**Re: The M12 (SSI-9364) – Submission on Environmental Impact Statement Amendment**

Council welcomes the opportunity to provide comments on the amended Environmental Impact Statement (EIS) for the proposed M12 Motorway between The Northern Road and the M7 Motorway. A portion of the project is in the Liverpool Local Government Area (LGA).

Figure 2-1 Key features of the amended project

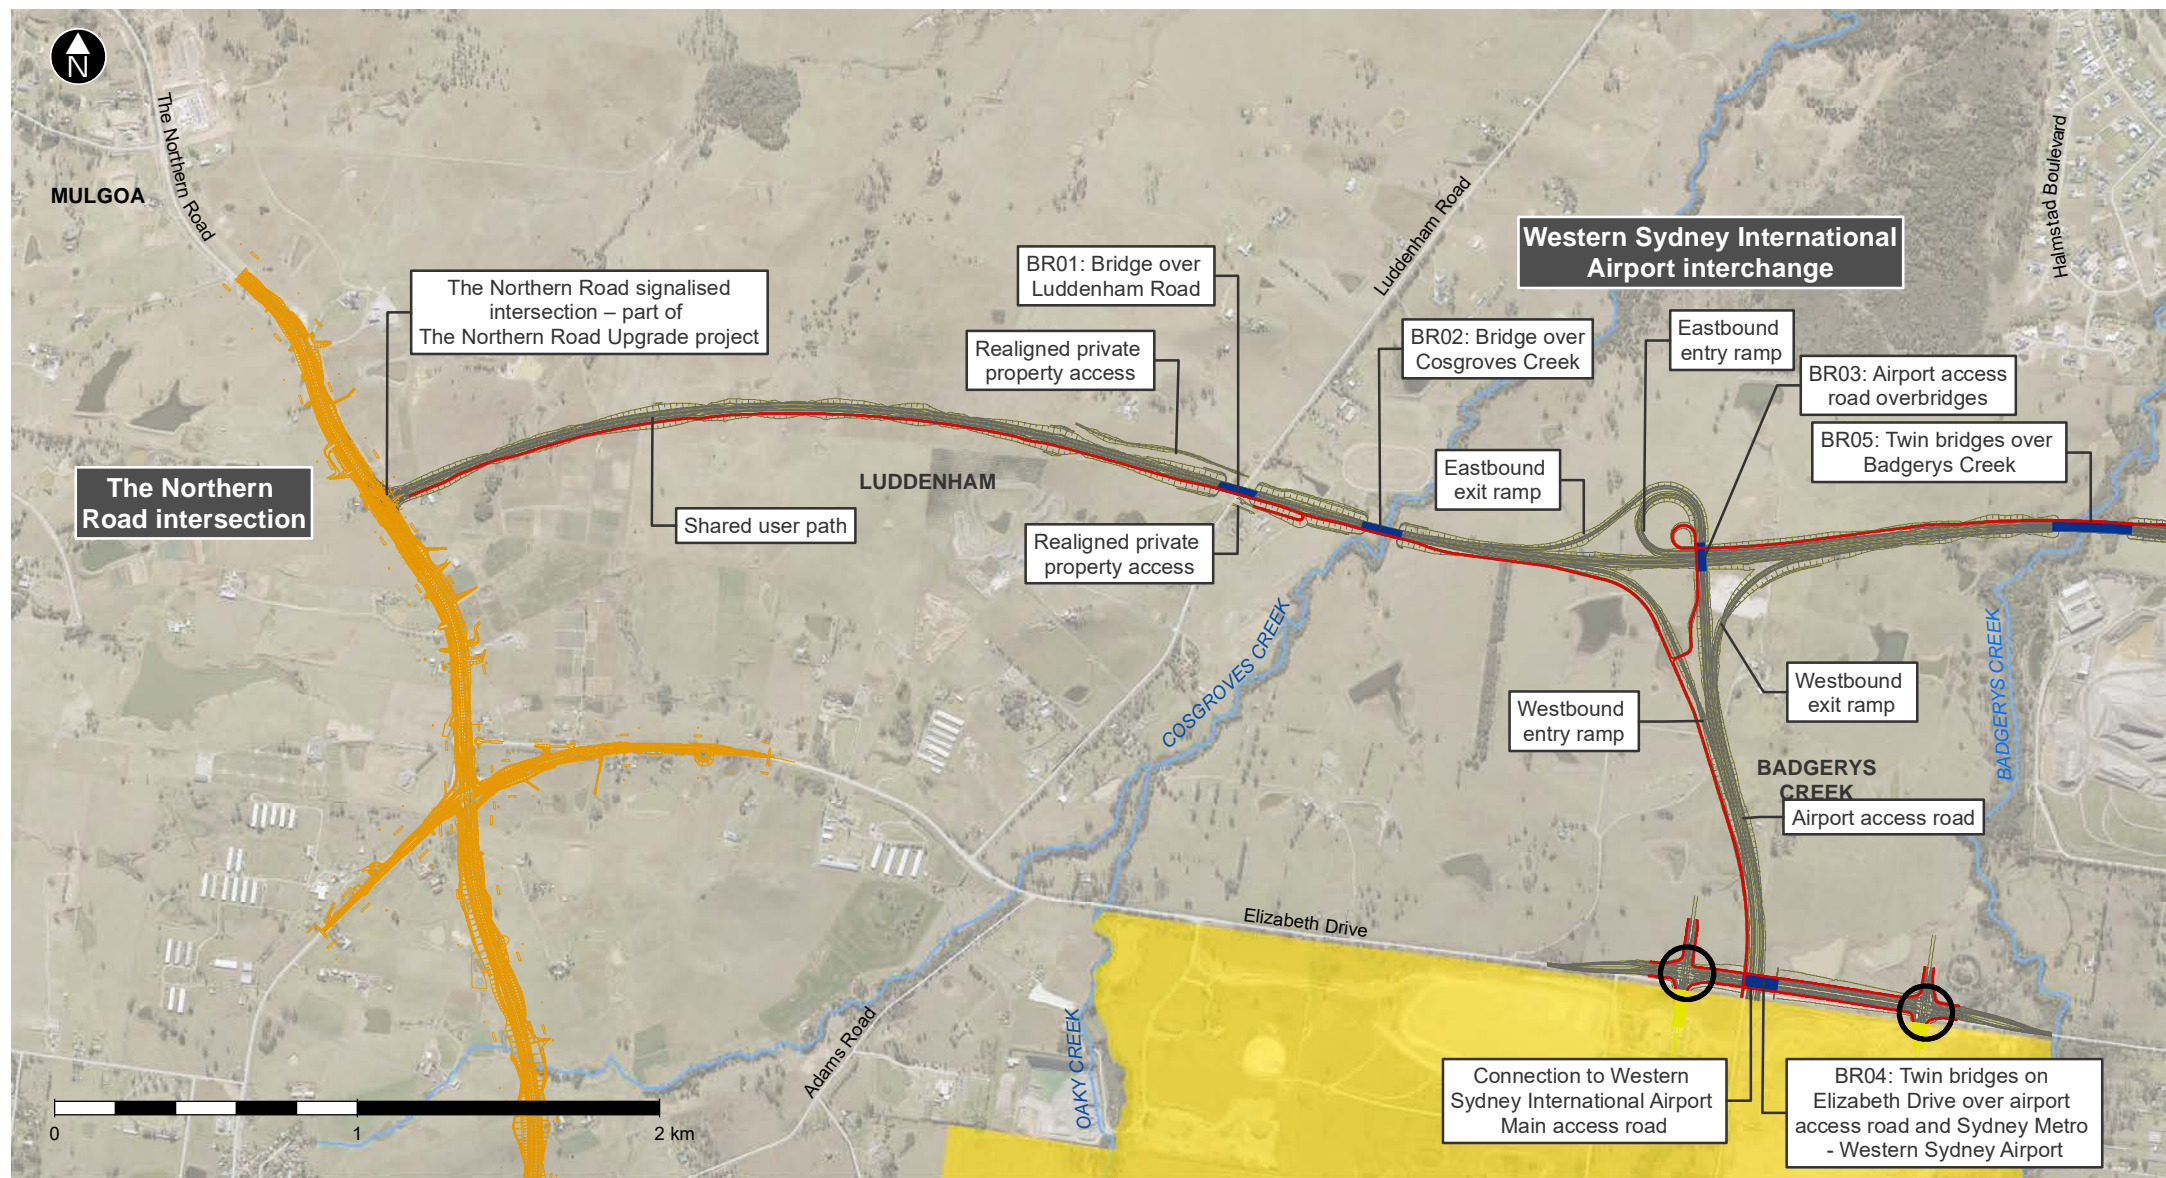
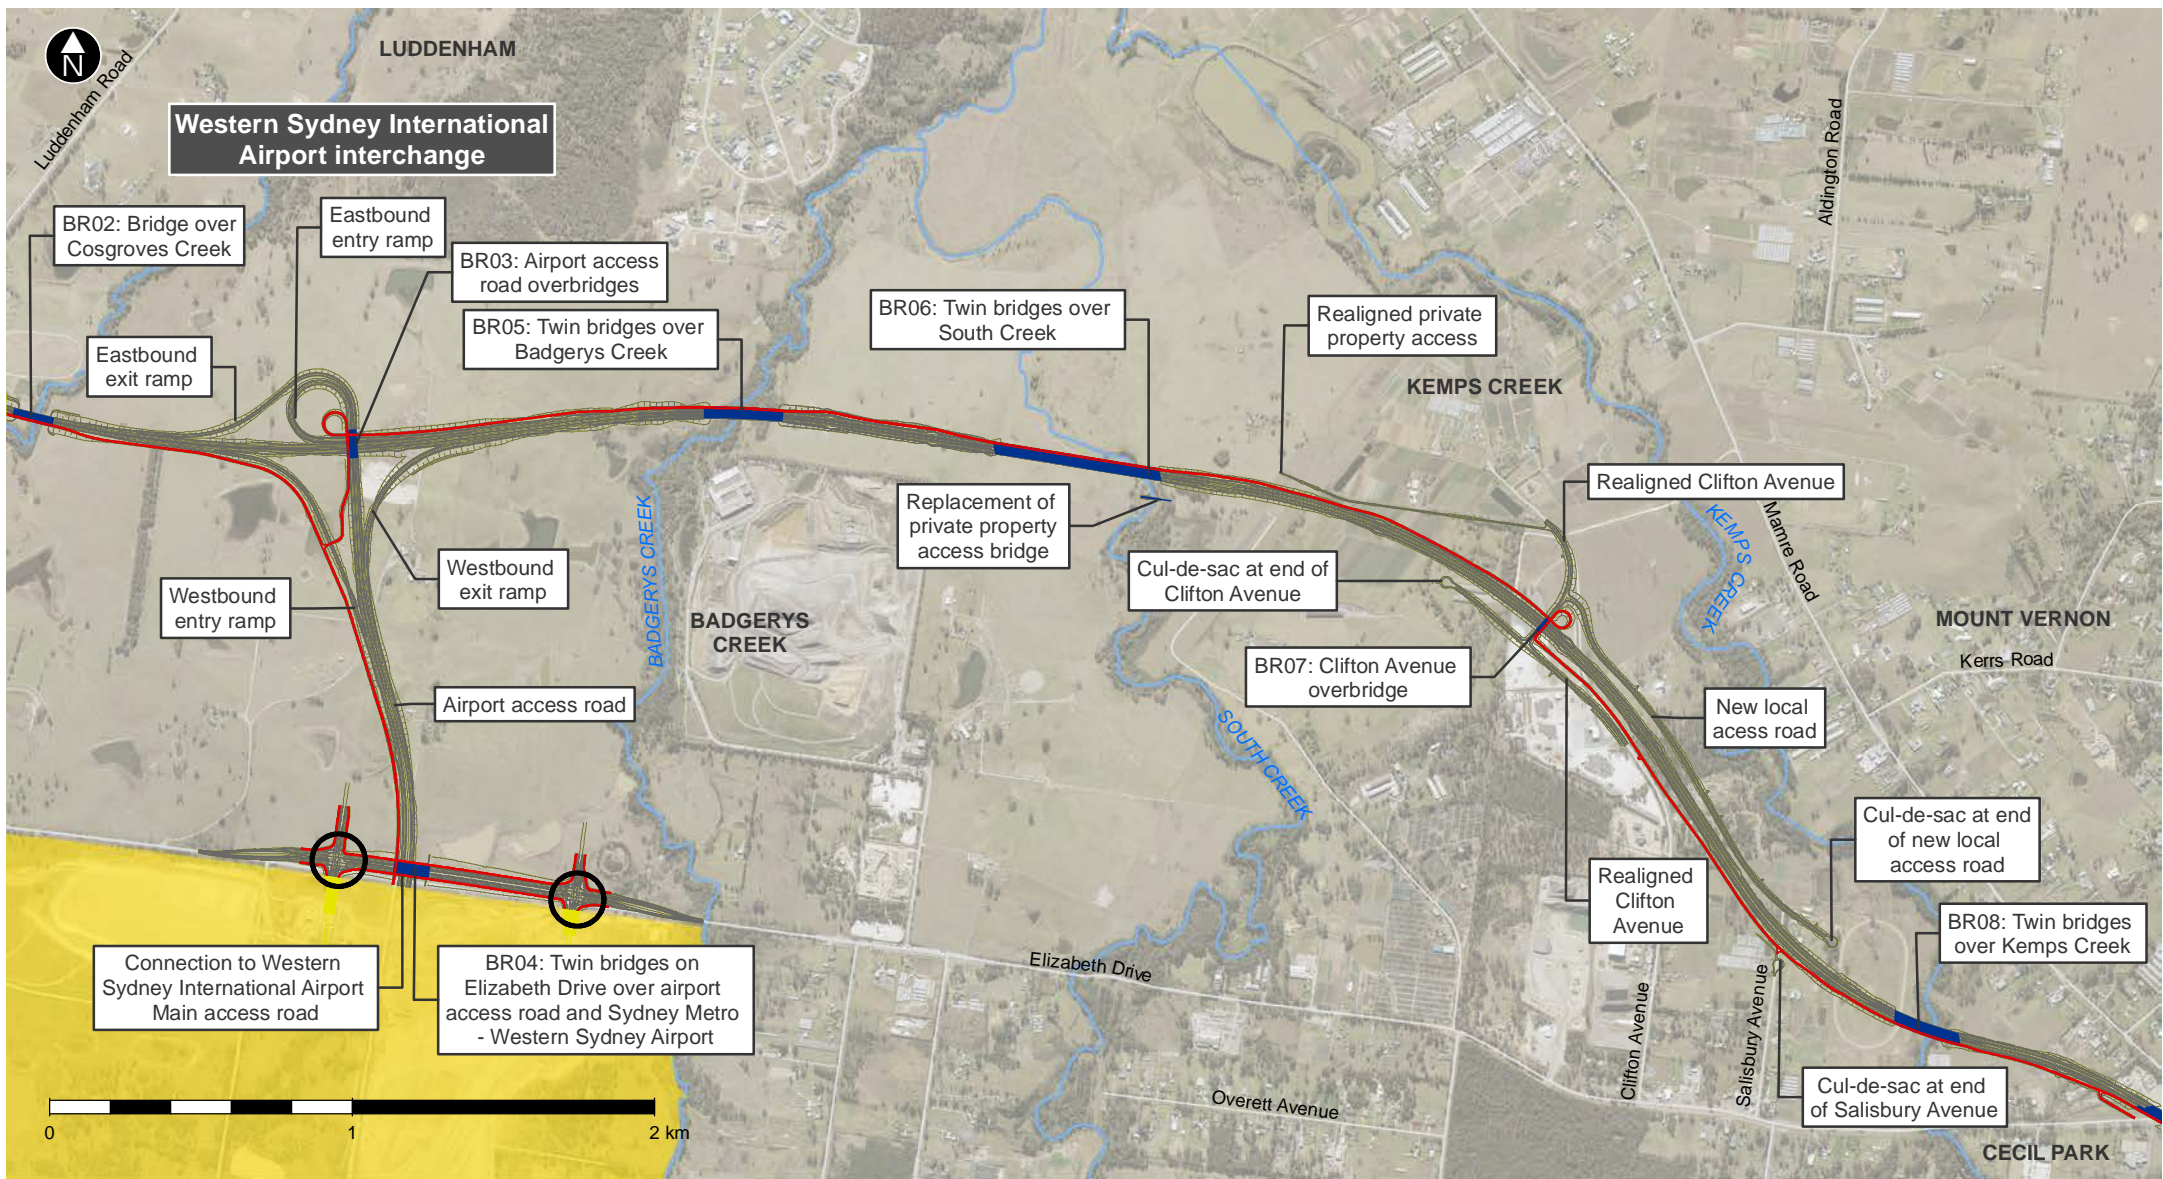
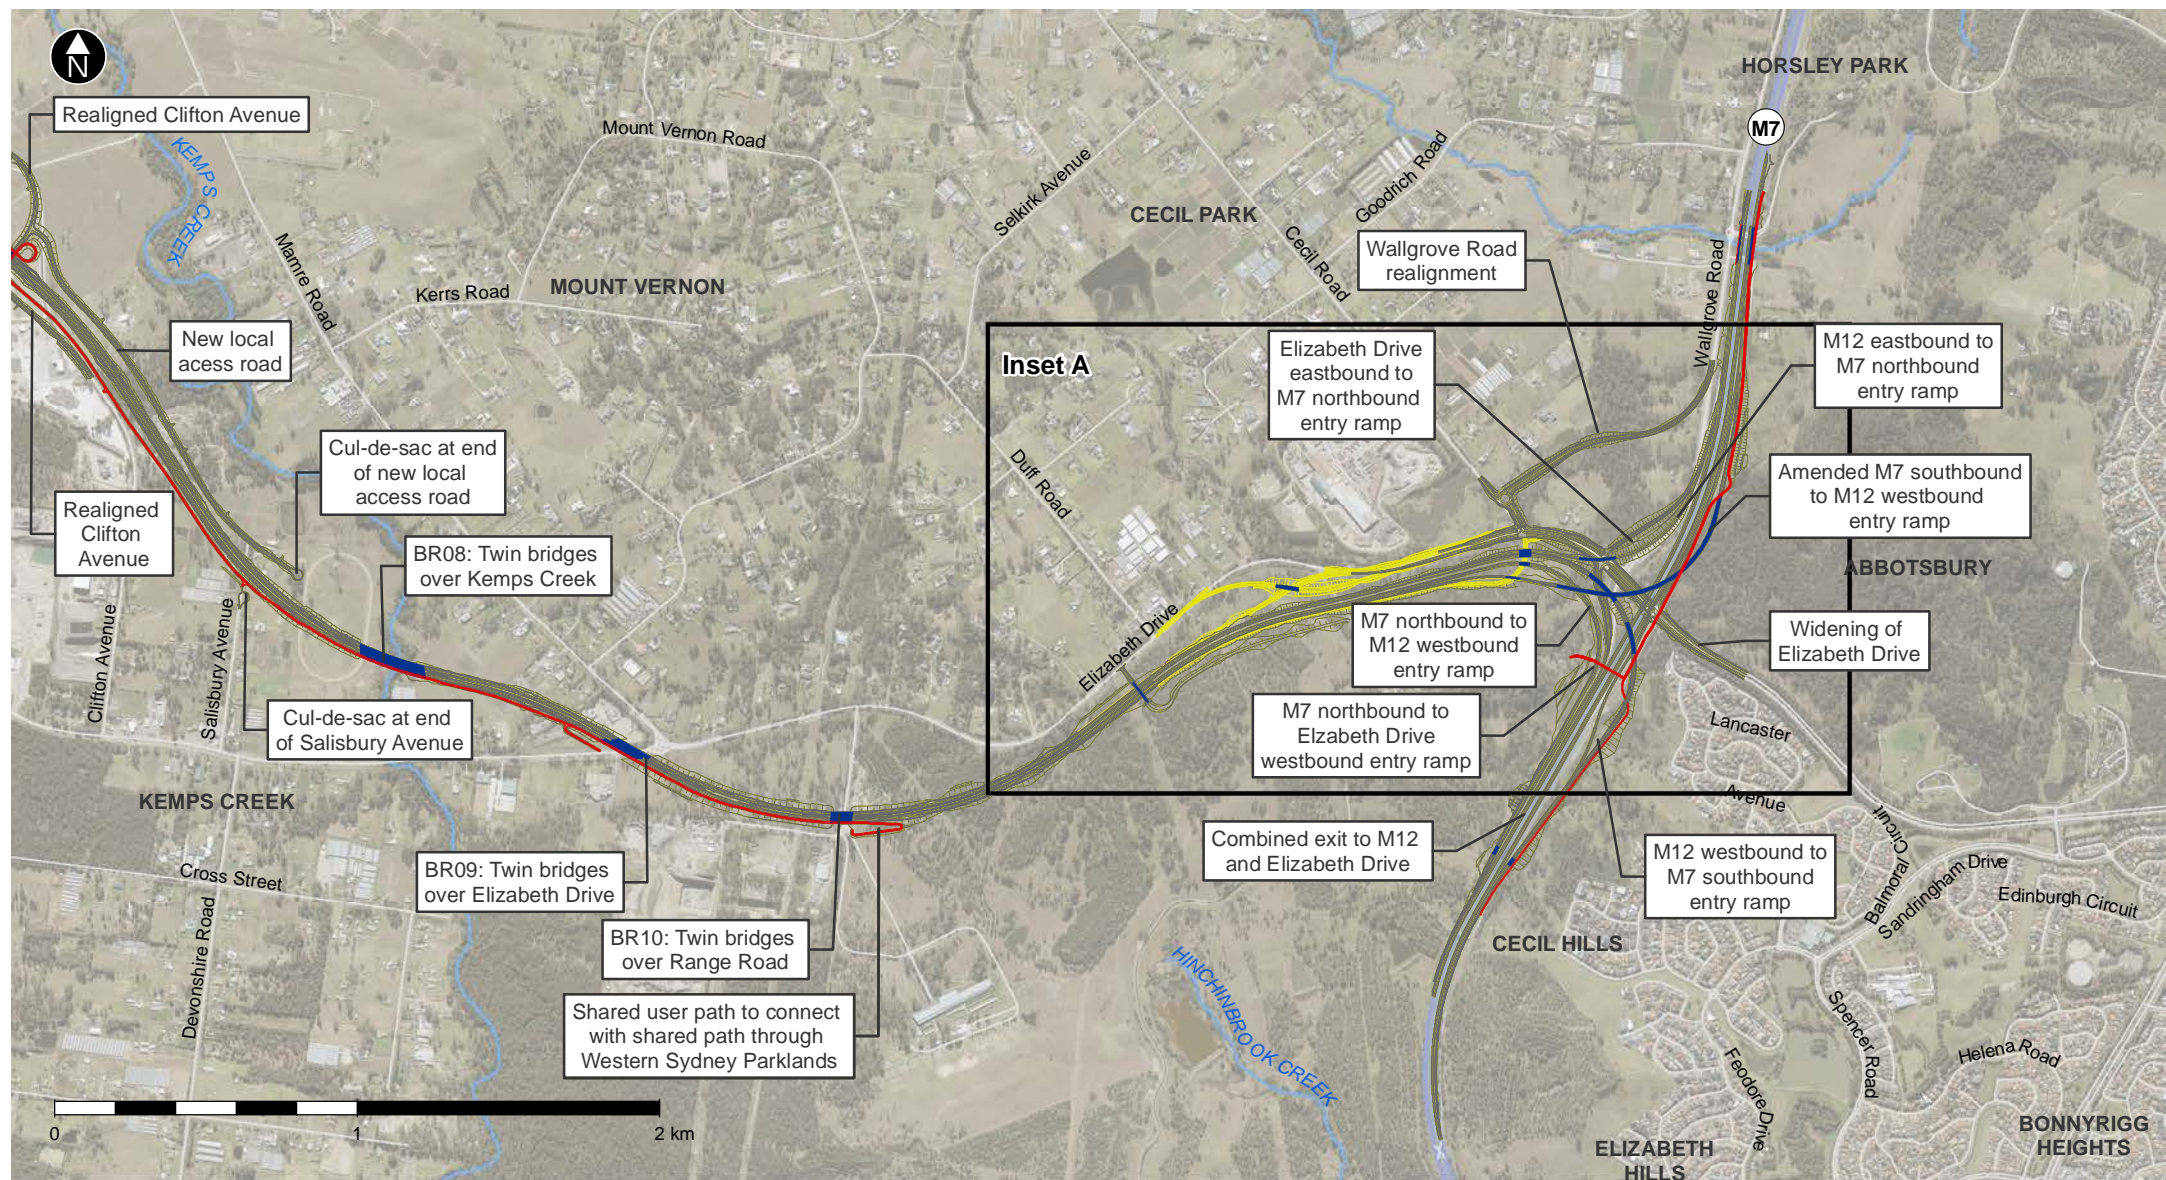
- Council supports the revised design option 2 which would provide the requested direct connection to and from Elizabeth Drive and requests that this option is funded and constructed as part of the project. Such a connection would provide essential local assets (from Fairfield and Liverpool LGAs to the Western Sydney Airport (WSA) via the M12 Motorway).
- Council notes and supports the revised design which will lower the M7 Motorway southbound exit to M12 Motorway westbound, and the M7 Motorway southbound entry from M12 Motorway eastbound, near Cecil Hills.

The revised EIS indicates that the design of the ramp would continue to be refined during detailed design to minimise noise and visual impacts on Cecil Hills residents. It is requested that TfNSW continues to work with Council on the detailed design to ensure that the revised design features would minimise noise and visual impacts (on Cecil Hill residents).
